Ref/Job No: 12SUTPLA-0009

19 October 2012

RE: Response to OEH regards to proposed filling and regrading works on OS2 and C3 lands as part of Stage 2A of the North Penrith Mixed Use Development

THORNTON PARK CONCEPT PLAN

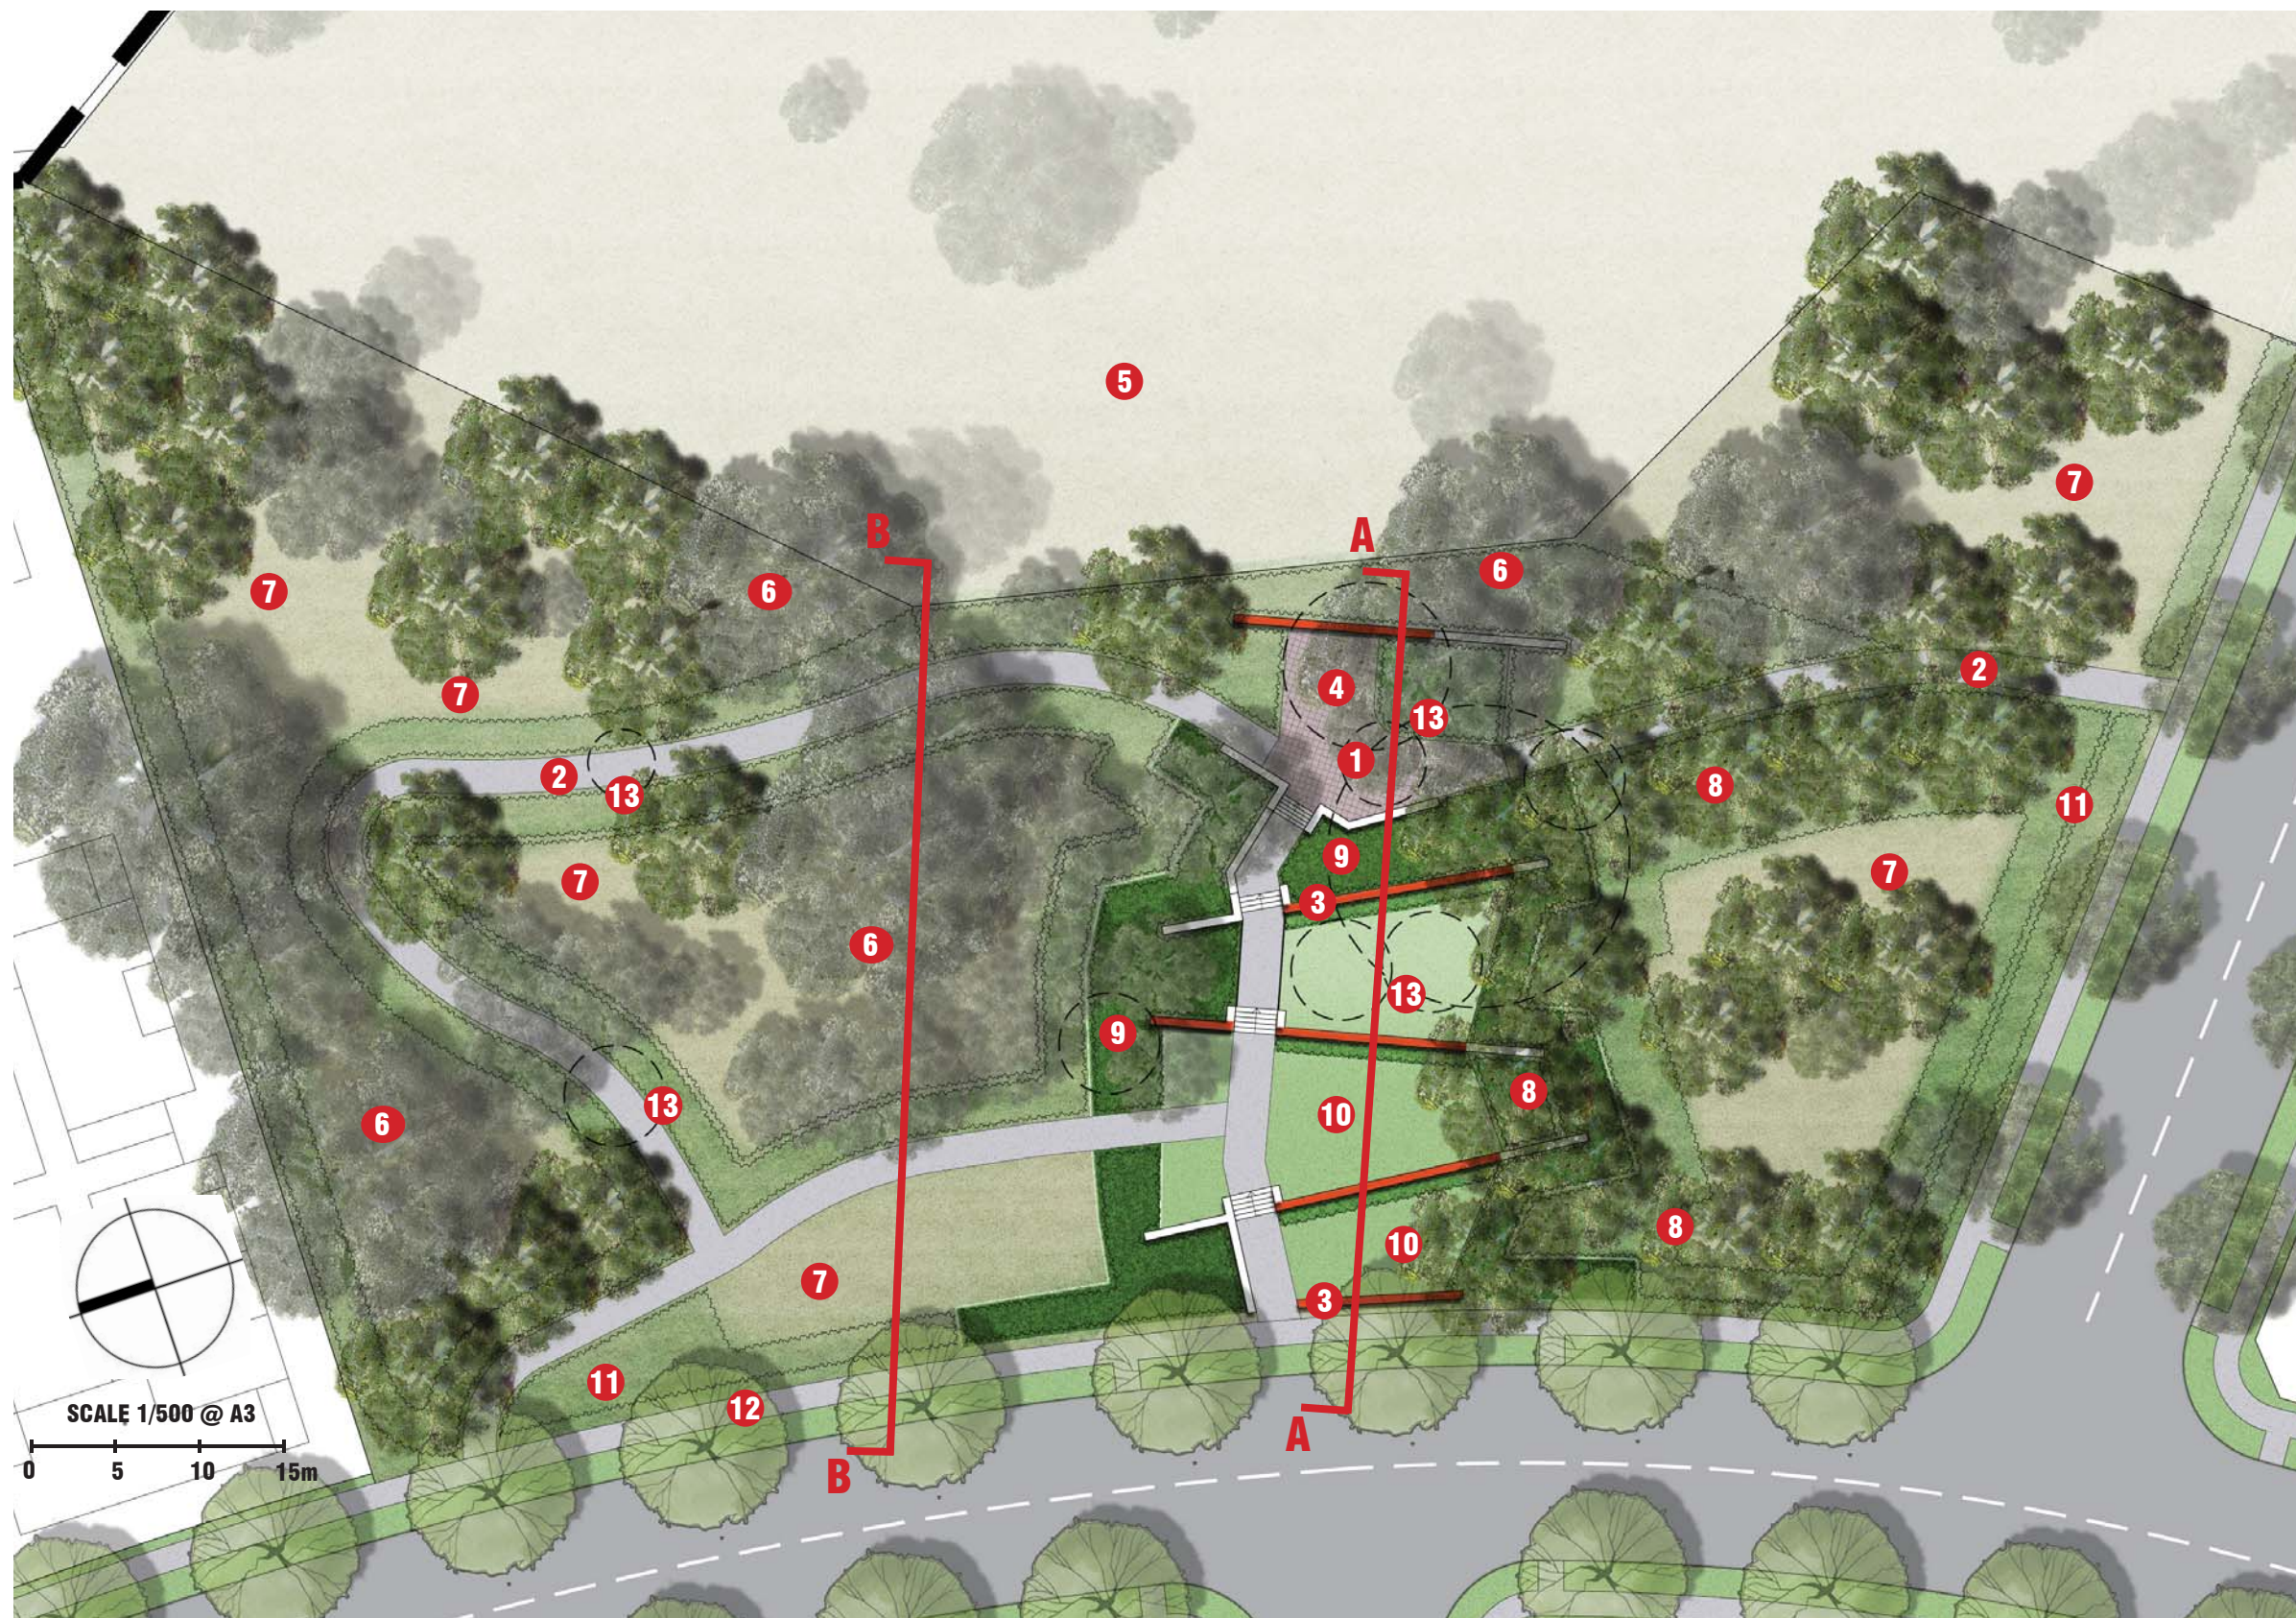
In the OS2 lands, the swale passes through two areas to be retained as bushland (**Figure 2**). In both there is significant regrowth of Spotted Gum along with heavy infestations of grassy weeds such as Rhodes Grass and *Eragrostis curvula* (African Lovegrass) in the open areas and sparse to moderate infestations of woody and herbaceous weeds such as *Olea europaea* subsp. *cuspidata* (African Olive), *Ligustrum lucidum* (Large Leaved

Due to the native vegetation regrowth in both the Section 88b covenant areas of the C3 lands and the bushland areas of the OS2 lands it is ELA's recommendation that these areas not be filled or regraded. In the OS2 land, given that a pathway will cut through the swale as part of the proposed development, it is suggested that sufficient drainage may be able to be incorporated into the pathways to redirect waterflow and avoid ponding.
